Case ref: EN0110014

### **Application by East Pye Solar Ltd for an order granting development consent for the East Pye Solar project**

#### **Advice following issue of decision to accept the application for examination**

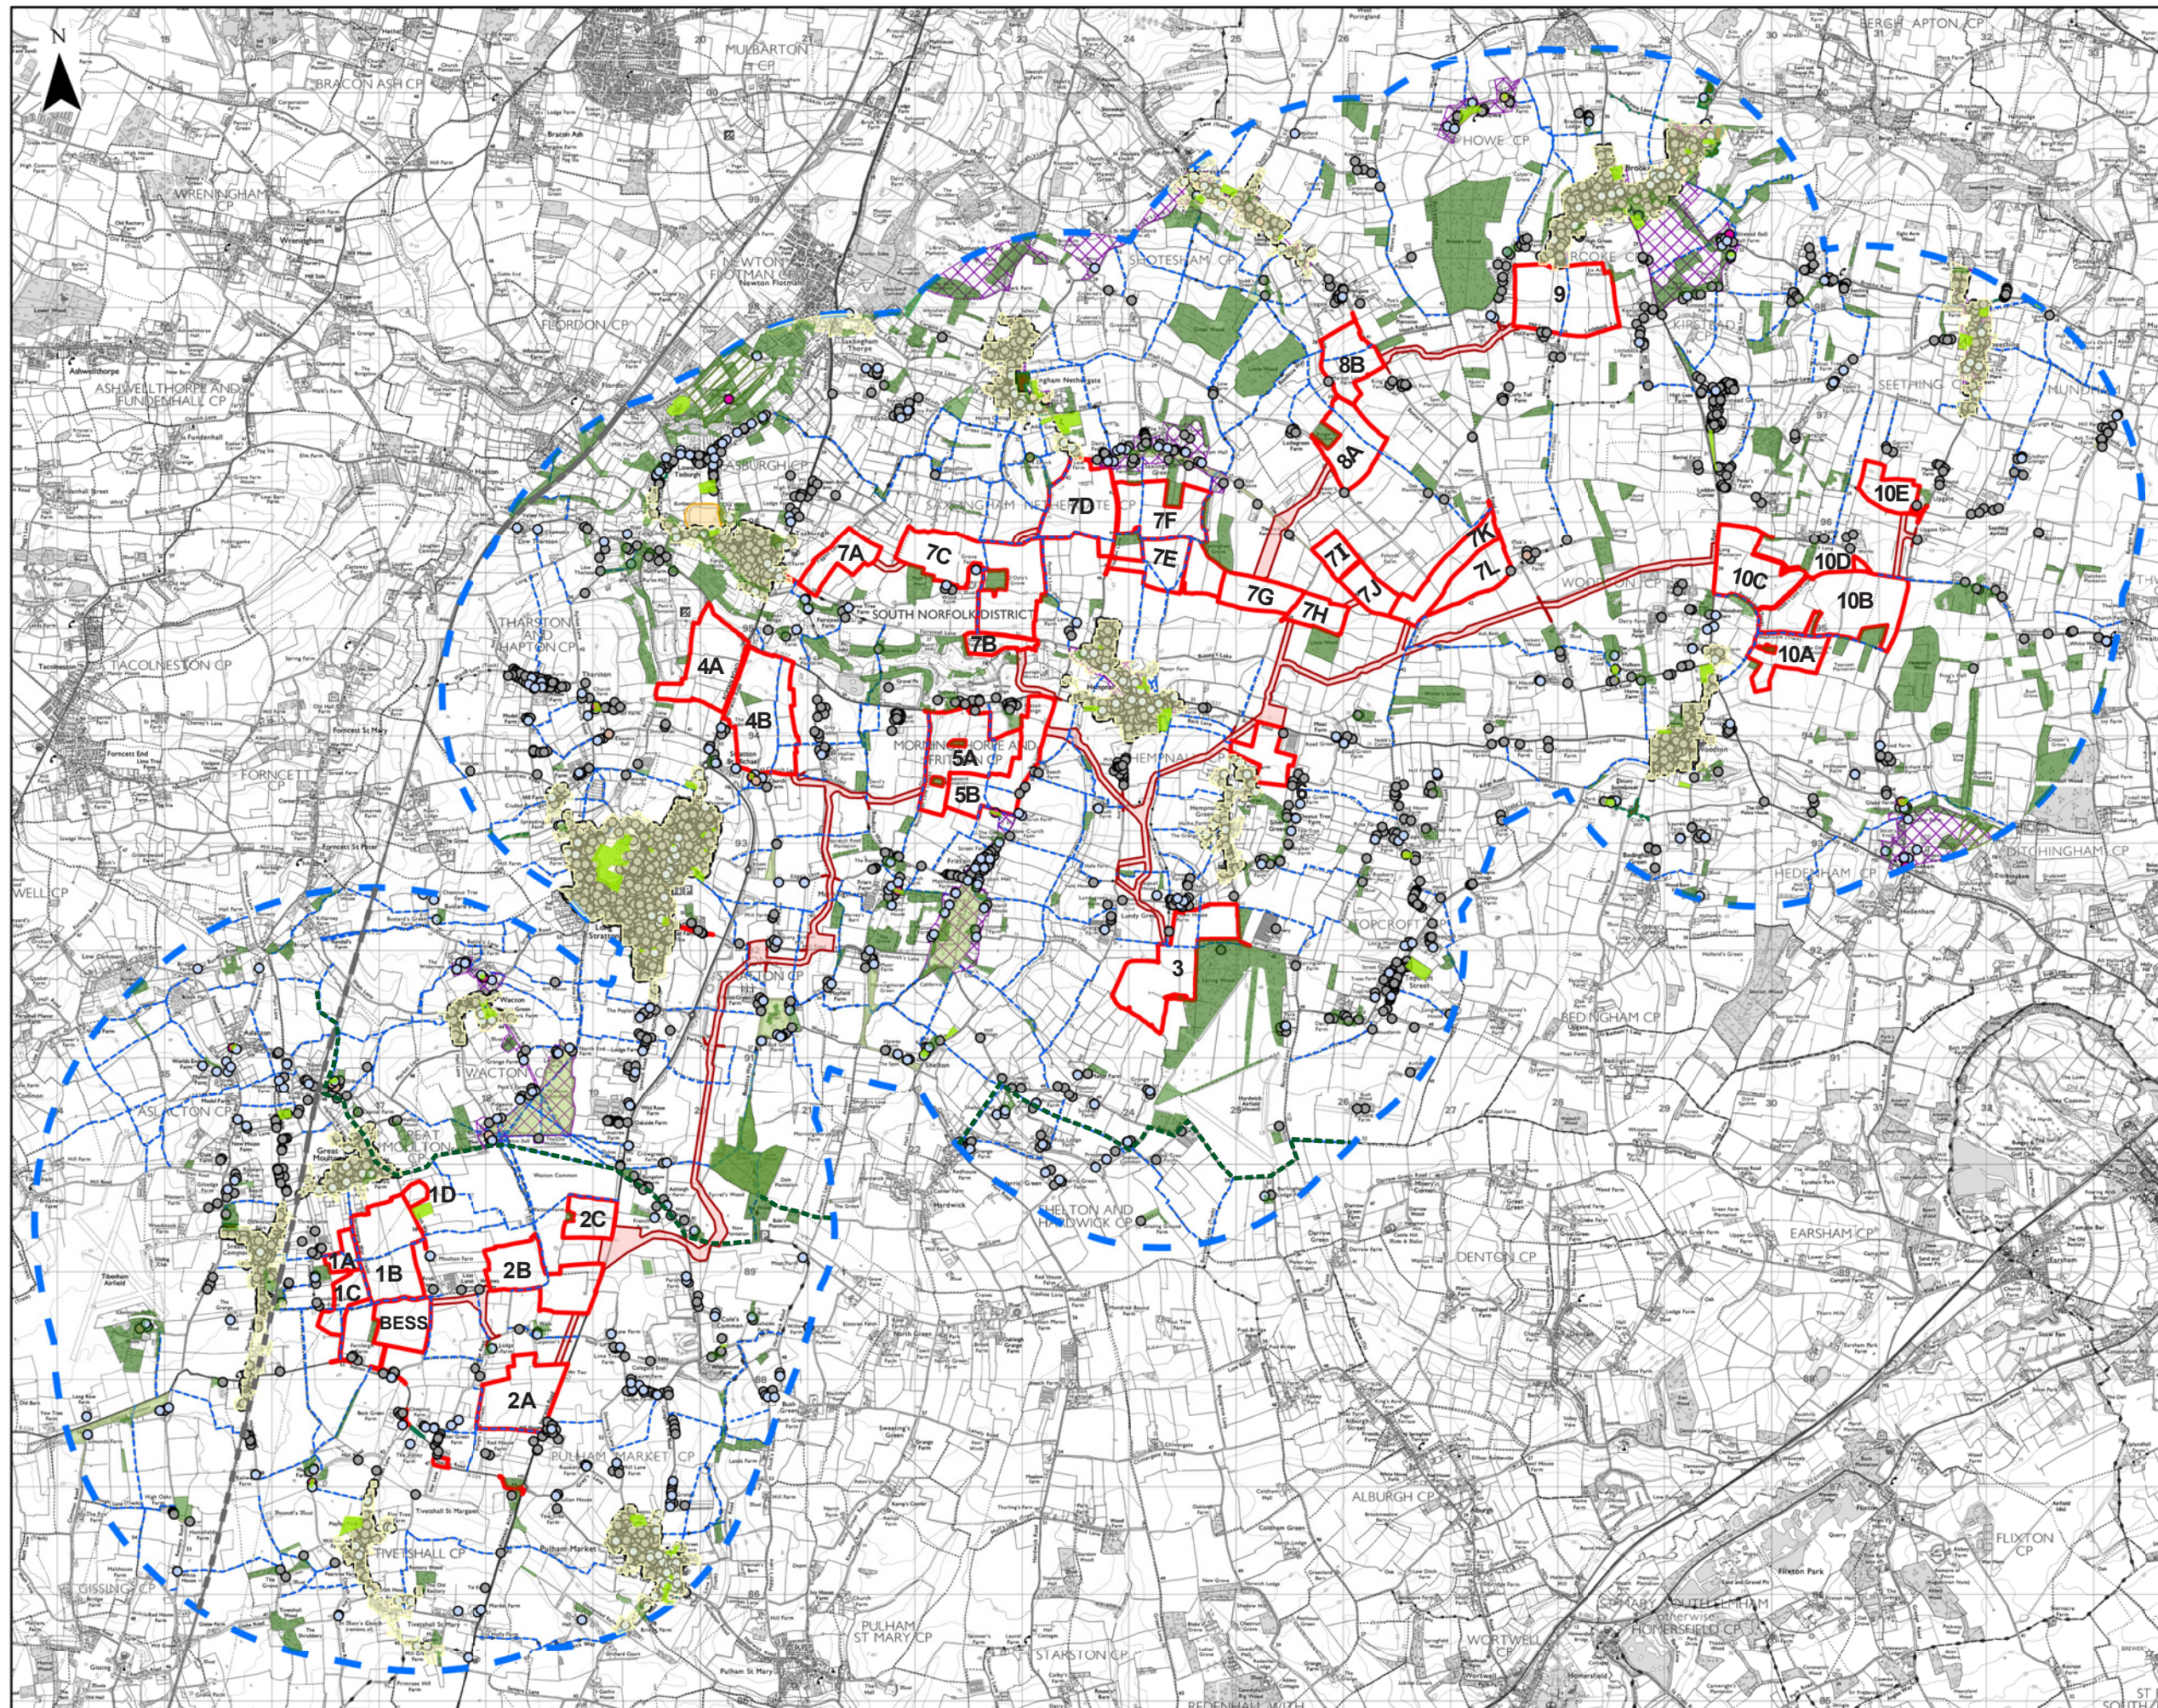
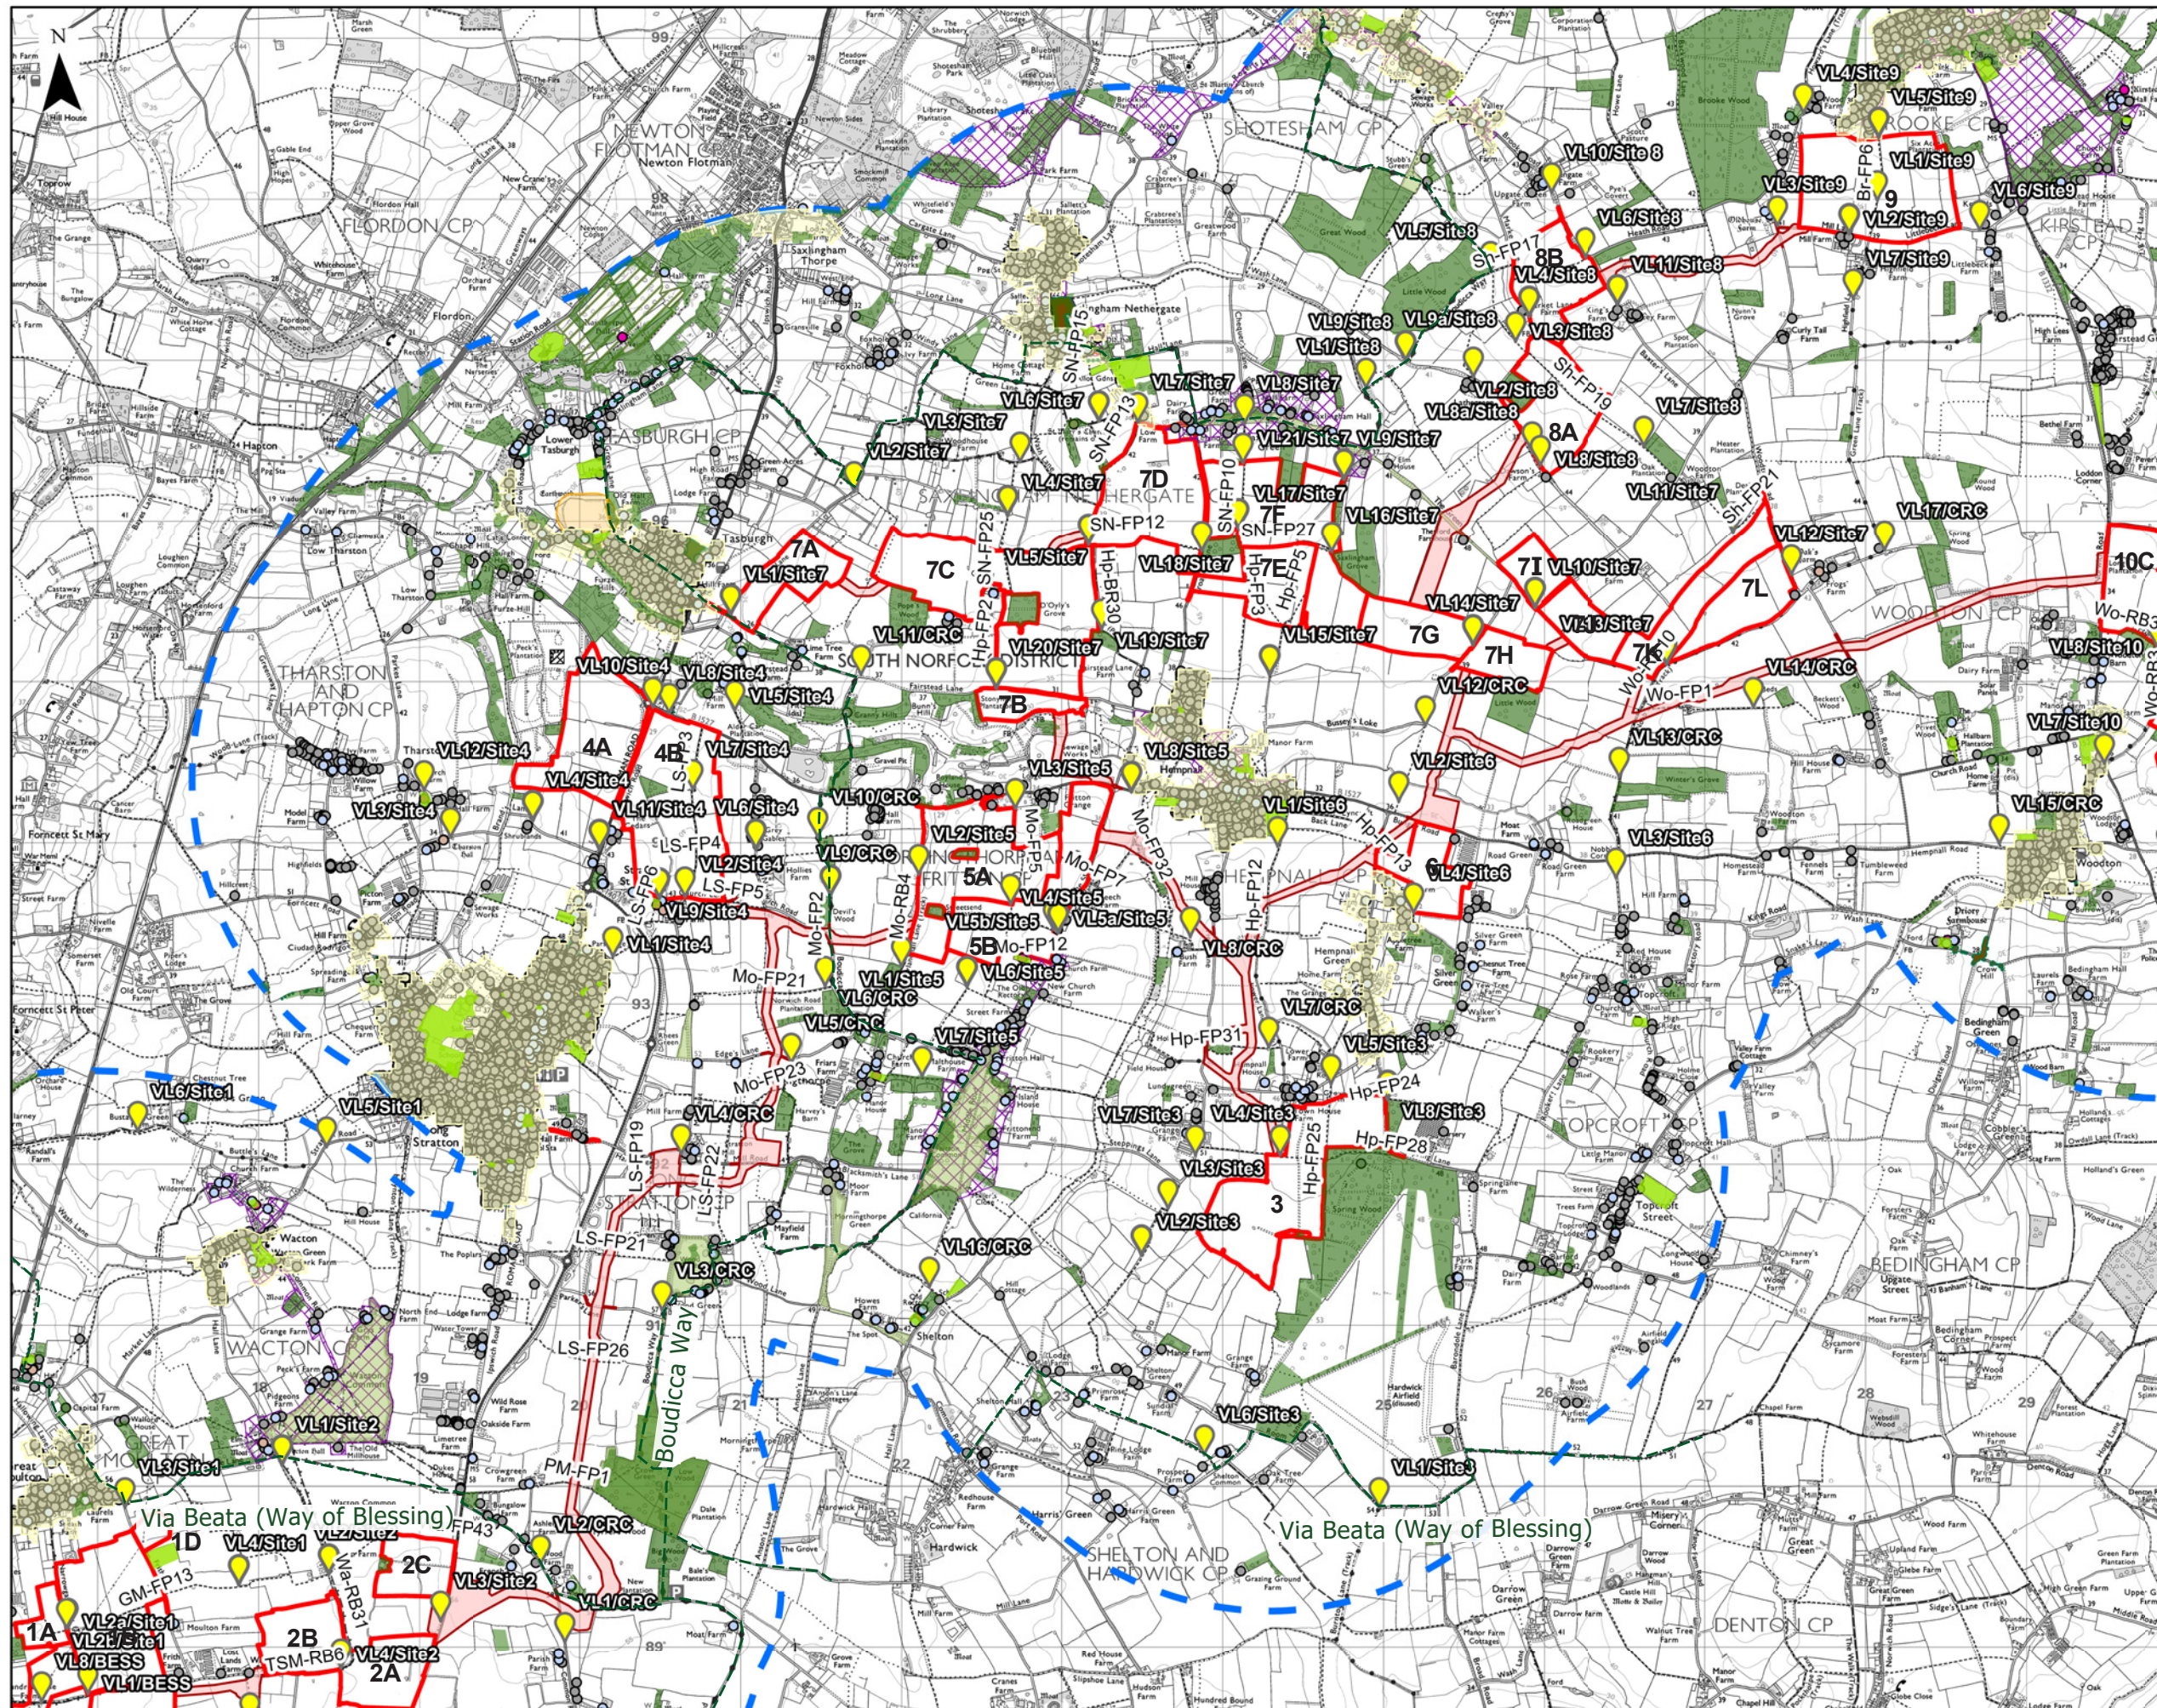
During the acceptance process, issues arose with the downloading and rendering when multiple plans and appendices were opened simultaneously. When a document has a relatively large file size, it can cause difficulties when being viewed on a computer screen. Partial or slow loading issues, and lengthy opening times were experienced by the Planning Inspectorate during the acceptance period. These issues are also likely to be encountered by interested parties, affected persons, the Examining Authority, and others during the examination.

The applicant is expected to manage document size. The applicant is asked to submit revised Volume 2 and 6 documents that eliminate rendering issues and allow multiple files to be opened concurrently. This applies to several figures (such as documents 6.2.5.4, 6.2.7.5 (10), 6.2.7.6, 6.2.7.7, and 6.2.15.1), which range in size from 42.5 MB to 90.8 MB, plan document numbers 2.3 (69 MB) and 2.12 (78.1 MB), as well as to appendices attached to Environmental Statement chapters, such as document 06.03.18.01, which is 145.9 MB.
